**KIRKLEES METROPOLITAN COUNCIL
INVESTMENT & REGENERATION SERVICE**

DELEGATED DECISION TO DETERMINE PLANNING APPLICATIONS

Reference No: 2021/62/92658/E

Site Address: The Abbey, 171, Abbey Road, Shepley, Huddersfield,
HD8 8DY

PROPOSED RAILINGS TO EXTERNAL BOUNDARY WALLS
SCALE 1:25

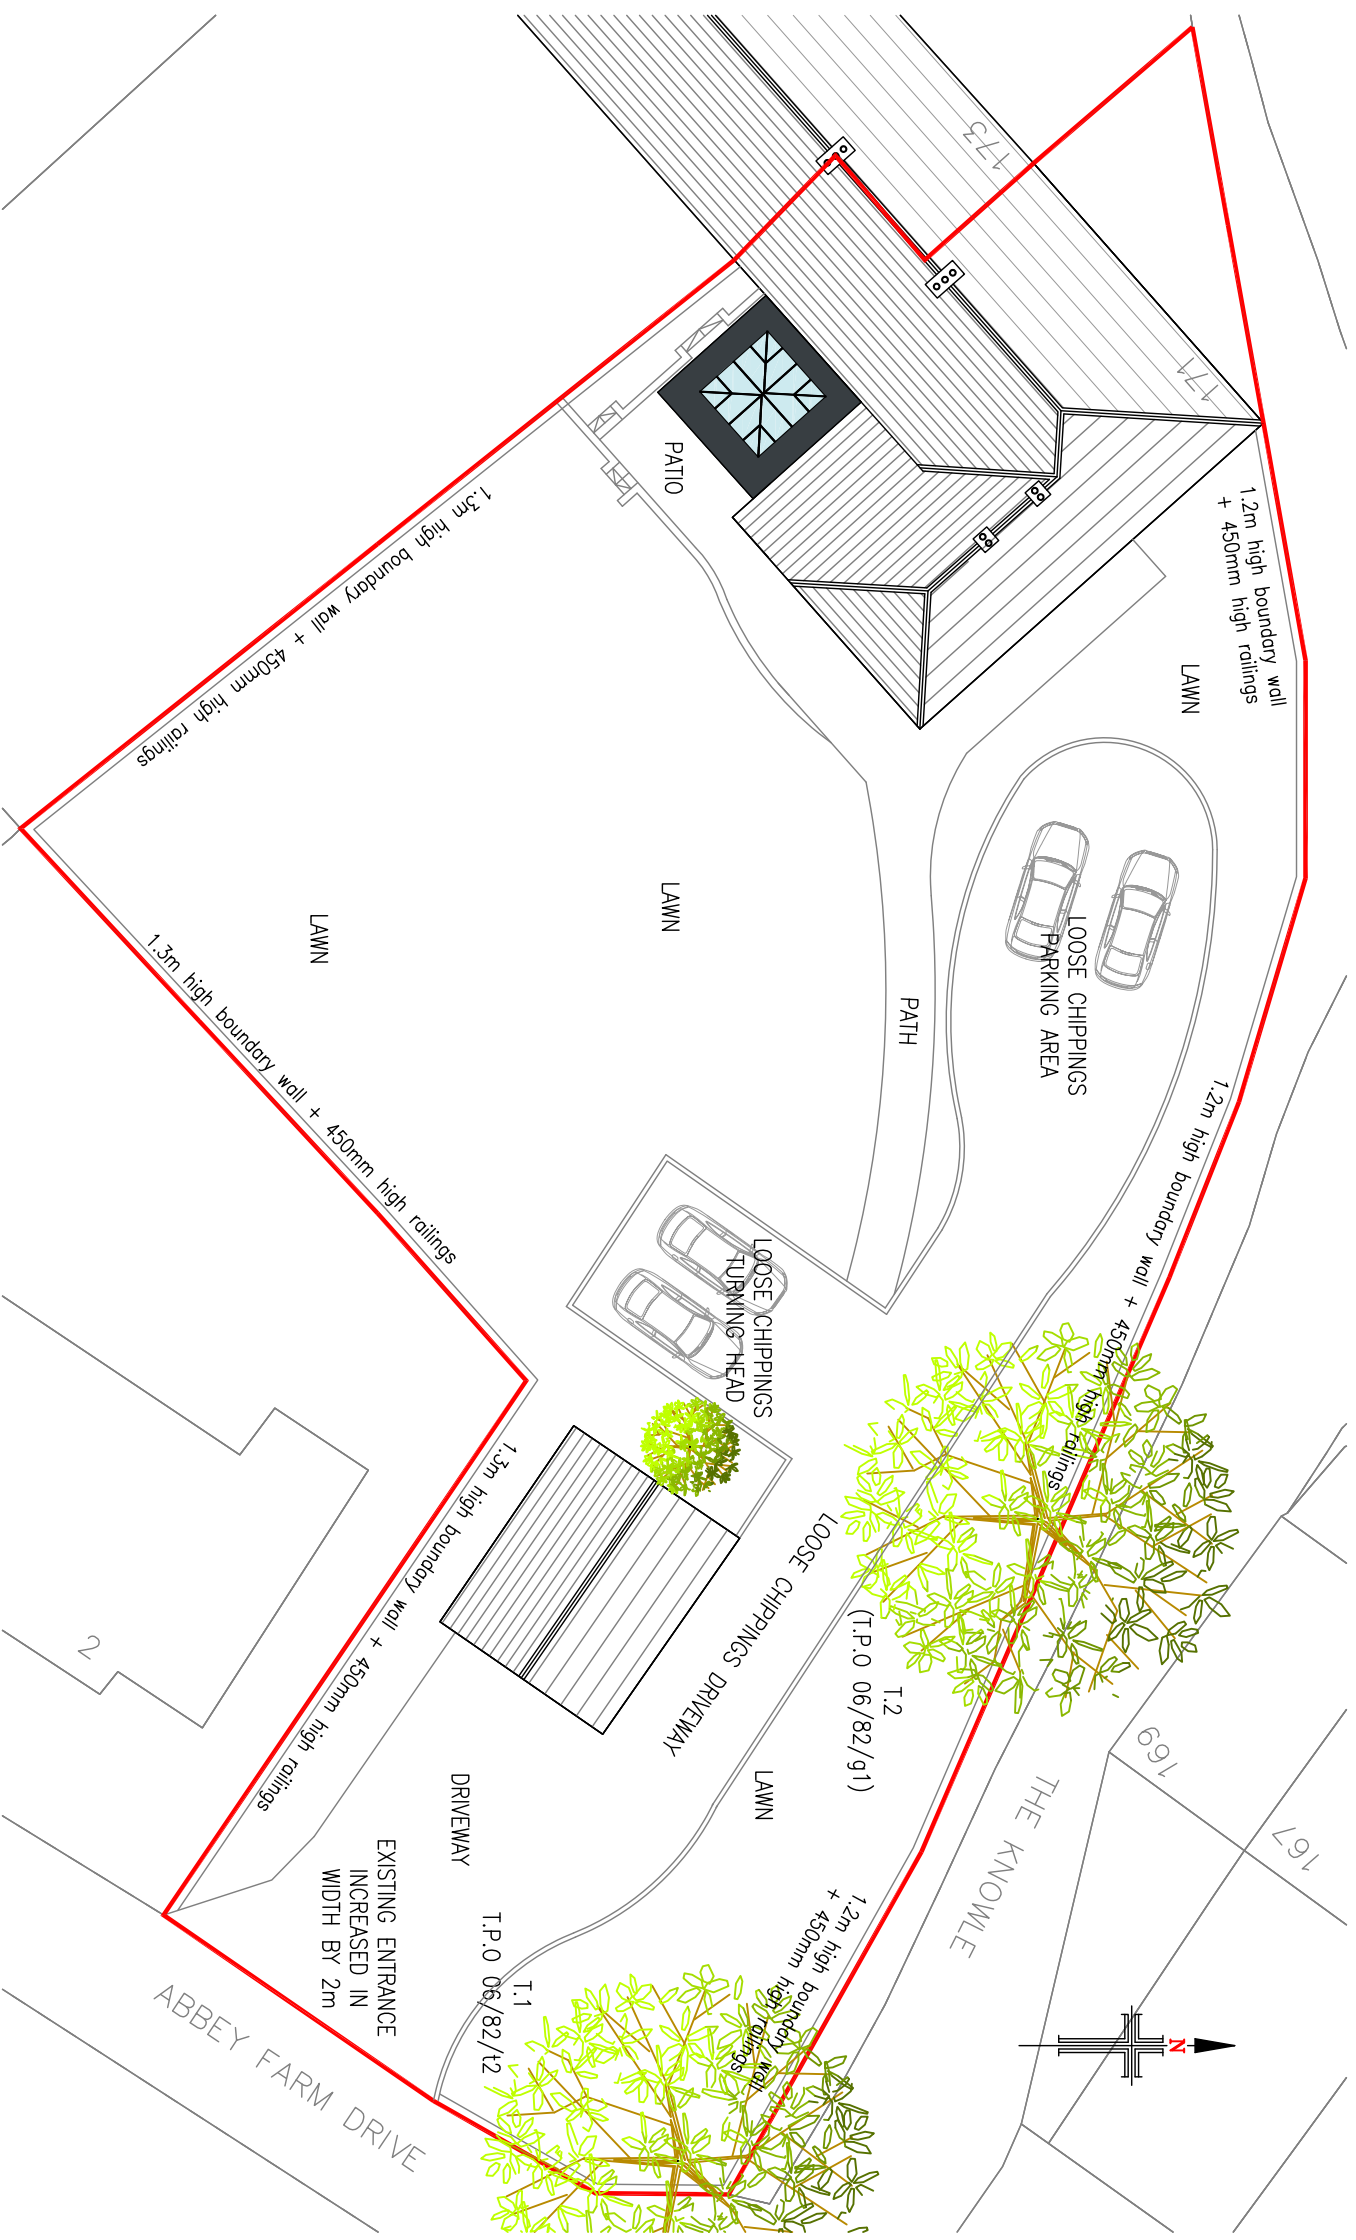
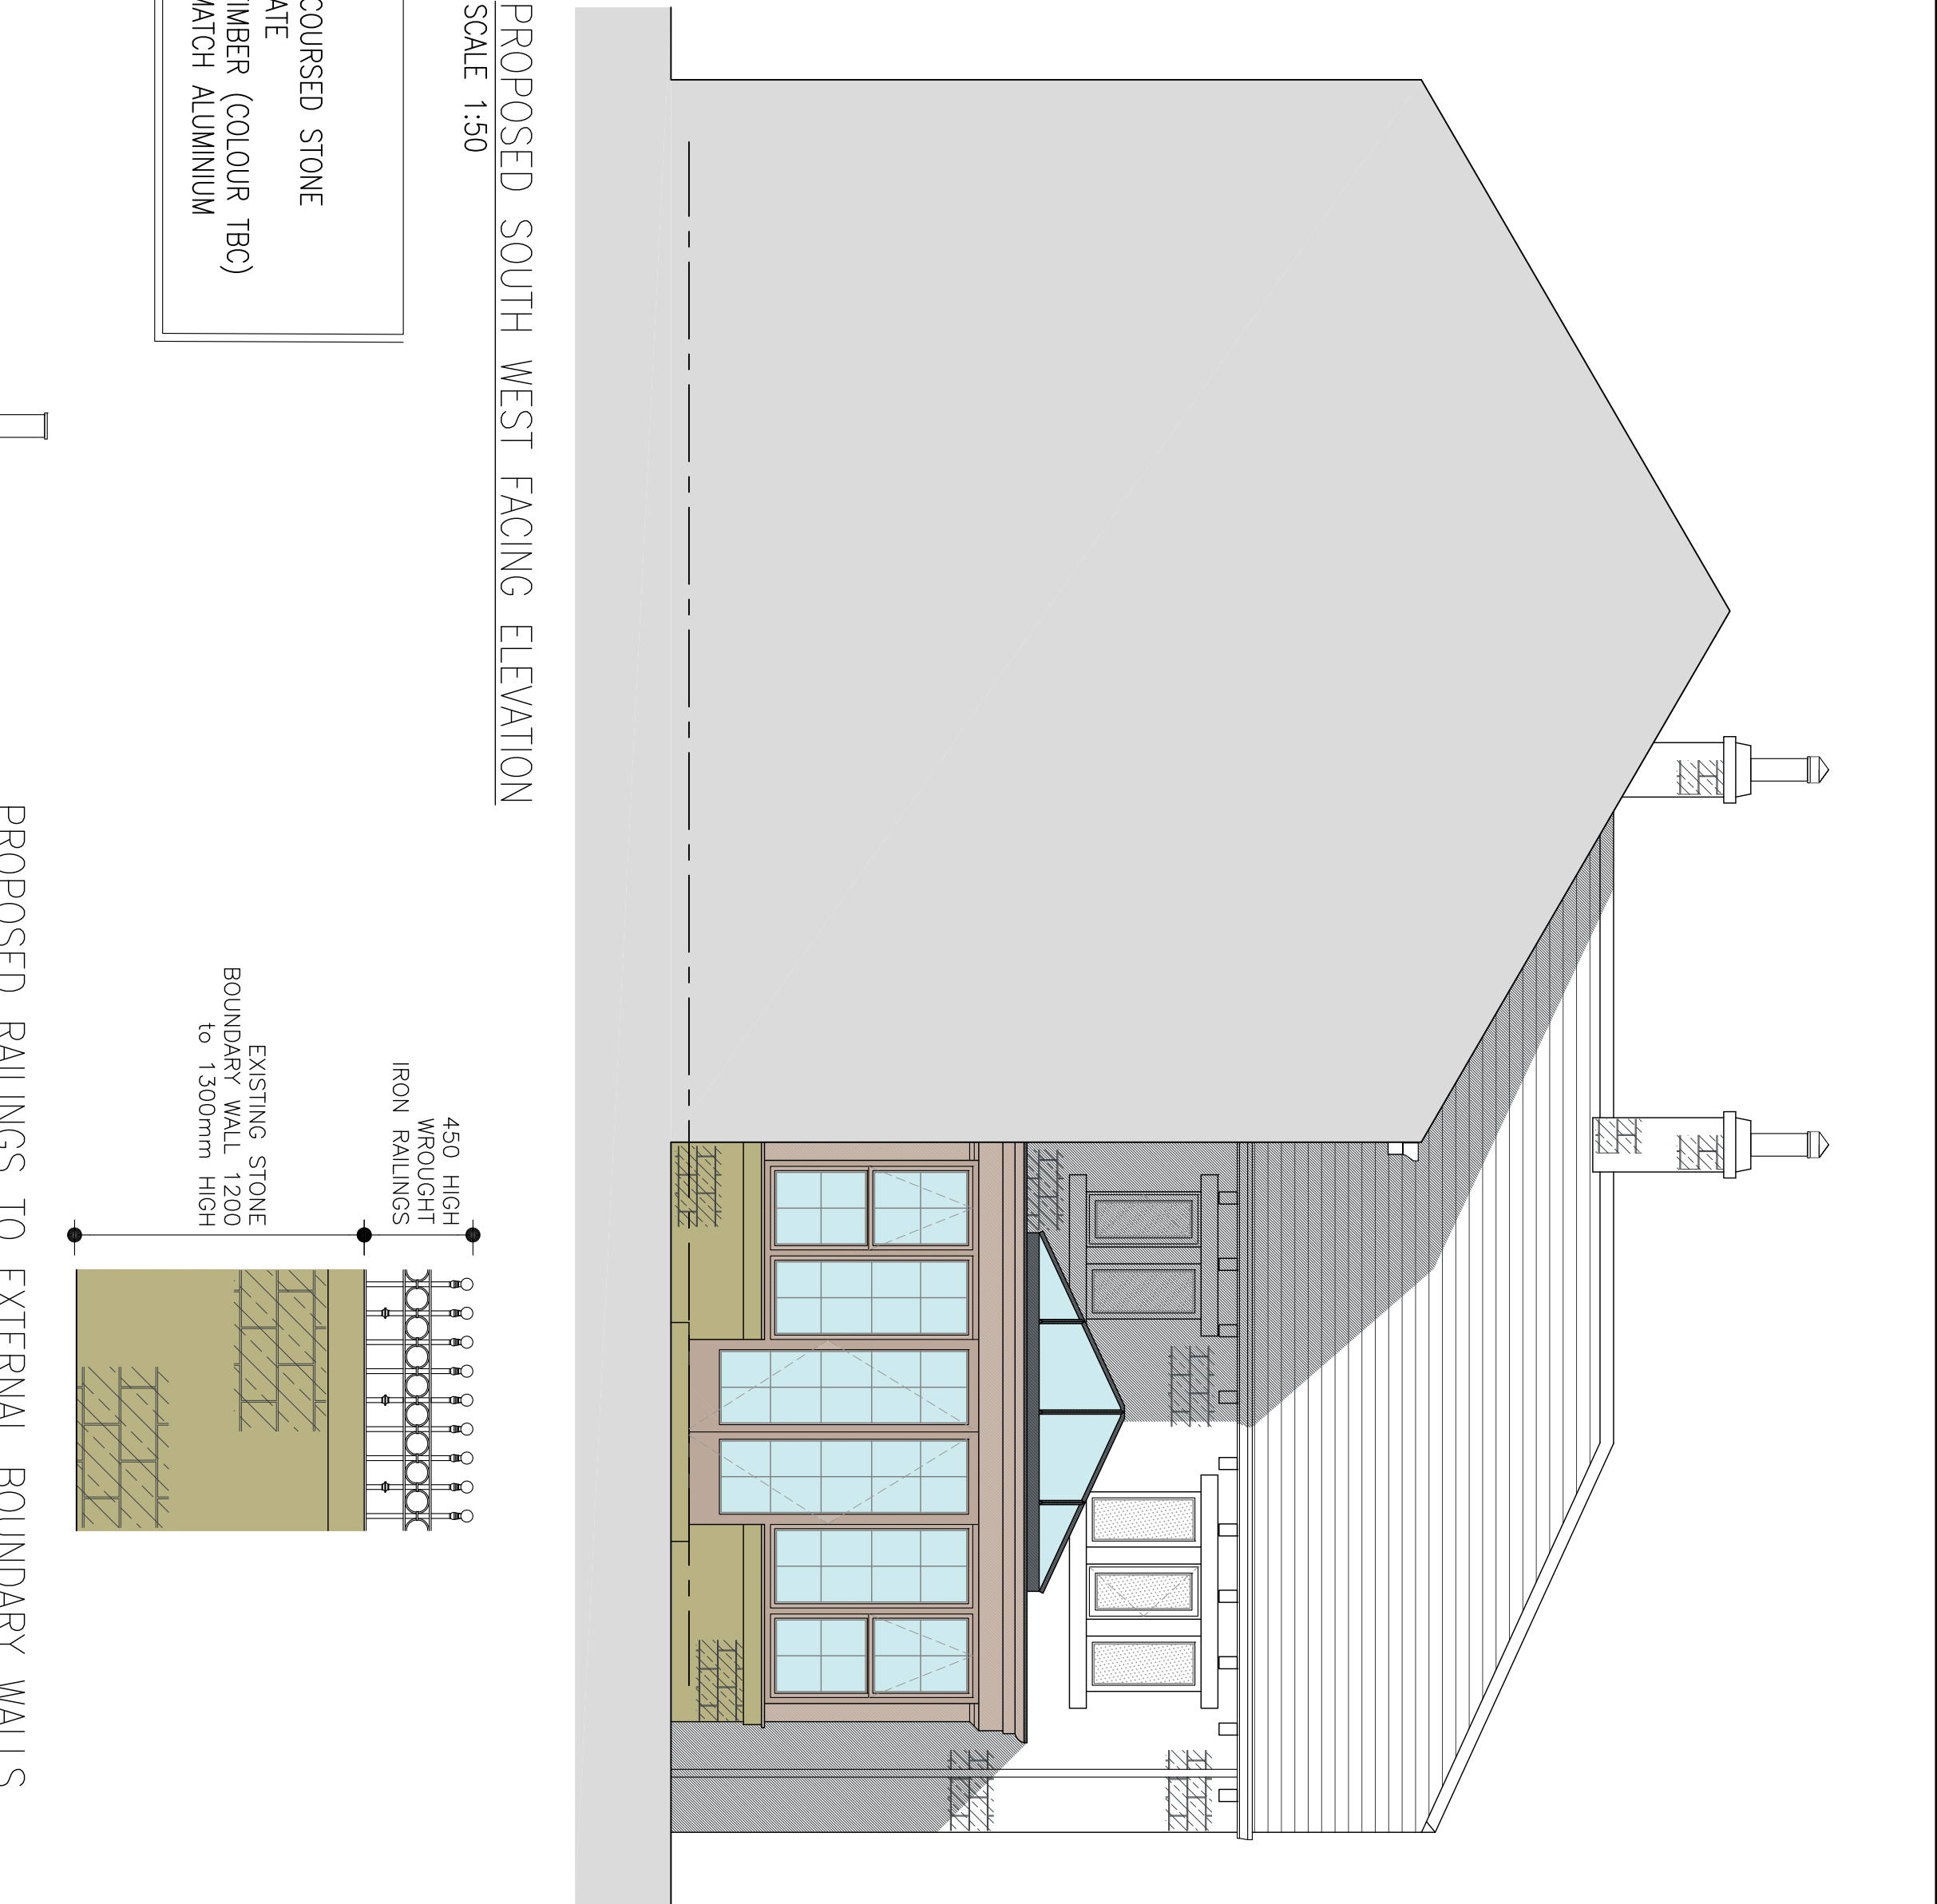
The KC Highways Development Management team asked that the first five metres of the access driveway be hard surfaced, so that loose chippings are not transferred onto the highway. The agent submitted amended plans demonstrating this, which are considered acceptable.

The KC Highways Development Management team requested that the first five metres of the access driveway be hard surfaced so that loose chippings would not be transferred onto the highway. The agent submitted amended plans demonstrating this, which are considered acceptable.
